Our Ref: D03579958/D03473543/D03437380/(F2017/00269)

28 June 2019

**RE: Randwick City Council comment on applicant's response on the State Significant Development Application: Doncaster Avenue Student Accommodation (SSD 9649).**

10&12 DONCASTER AVE - GROUND FLOOR PLAN

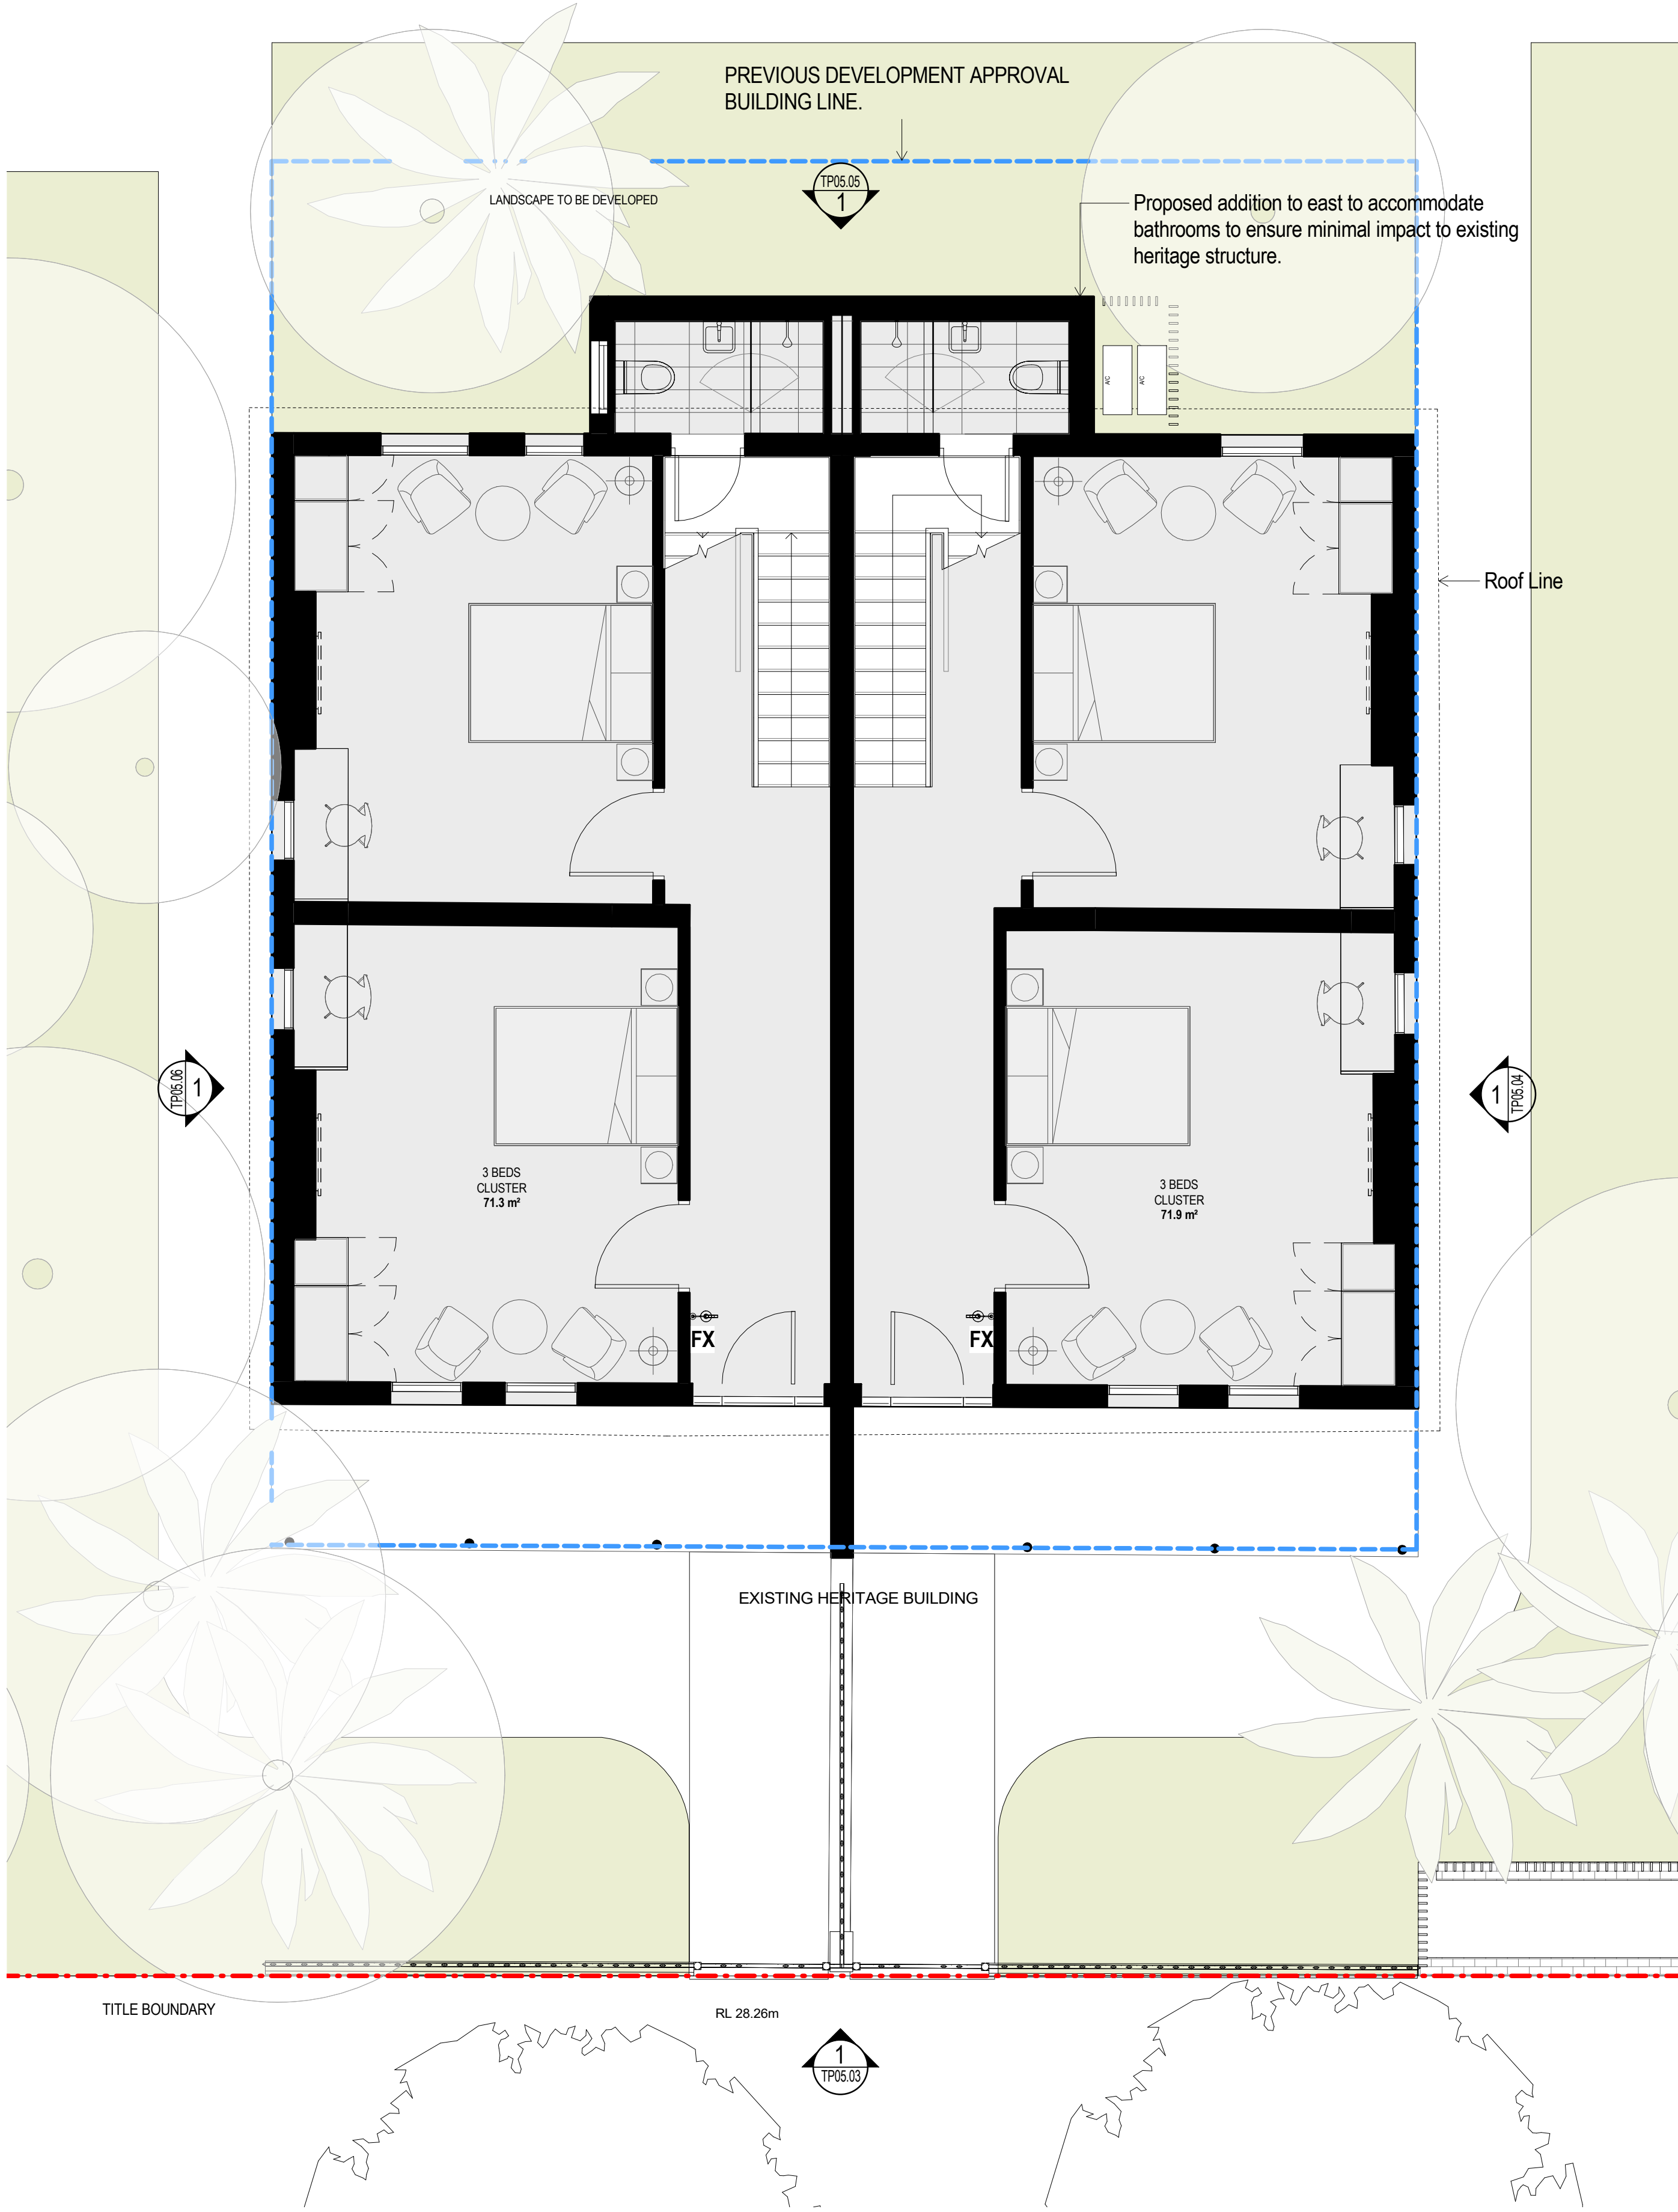
The size of 2 Level 1 boarding rooms in the retained heritage item exceed the 25sqm maximum GFA for boarding rooms (excluding private kitchen or bathroom facilities) in CL30(1b) of the AHSEPP. It is noted that a larger than minimum area may be provided for a Manager of the facility.

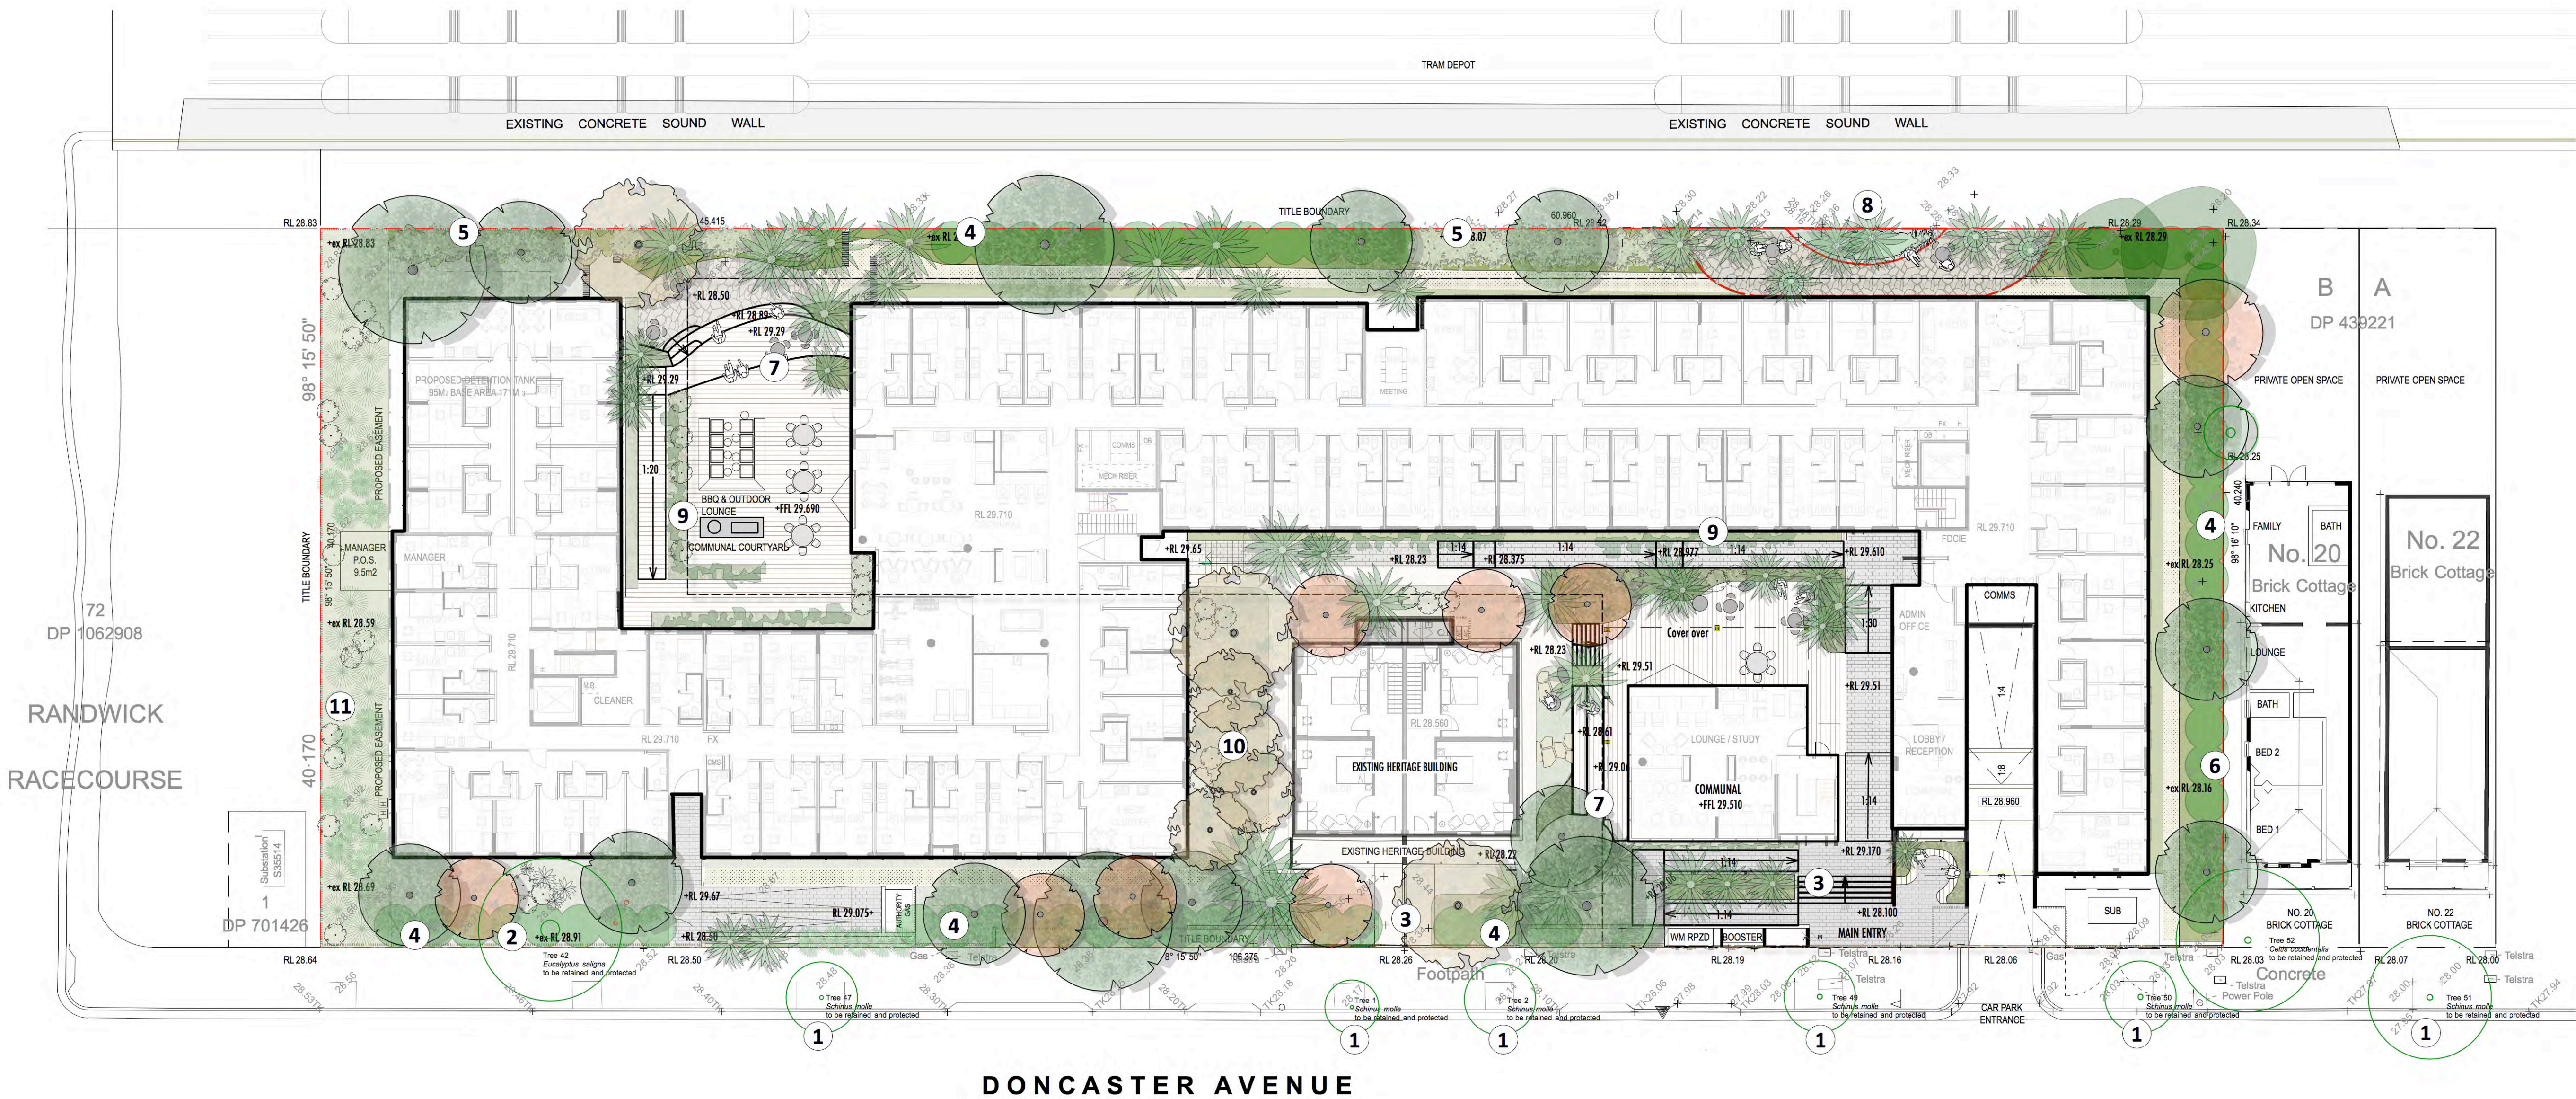
*All of the Landscape Plans show a high level treatment, so would be supported. However, Planting Plans are required to show exactly what is going where, and quantities etc, so for instance, we can ensure that adequate screen planting is provided for the private property to the south, as well as of the Tram yard to the east.*

Please note: The selection of screen planting on the southern side should consider species that do not result in encroaching branches and their height at maturity will not result in adverse visual impacts and overshadowing.

*A major concern remains, the separation that will be provided between Tree 42 and the above ground parts of the building at the northwest corner of the site. It seems the original setback we considered was 5900mm (6.2m measured from the blue dashed line in the amended plans), however it is much less now and appears to be only 3.44m from the trunk.*

The proposed footprint has the potential to affect its crown, which given its prominence in the site/street is a concern, particularly as it's the only established tree that is retained. No root mapping has been performed at this reduced setback either, which would inform the amount of root activity and potential impacts. It is recommended a detailed report on both aspects before consideration of the reduced setback. The basement setback remains acceptable.
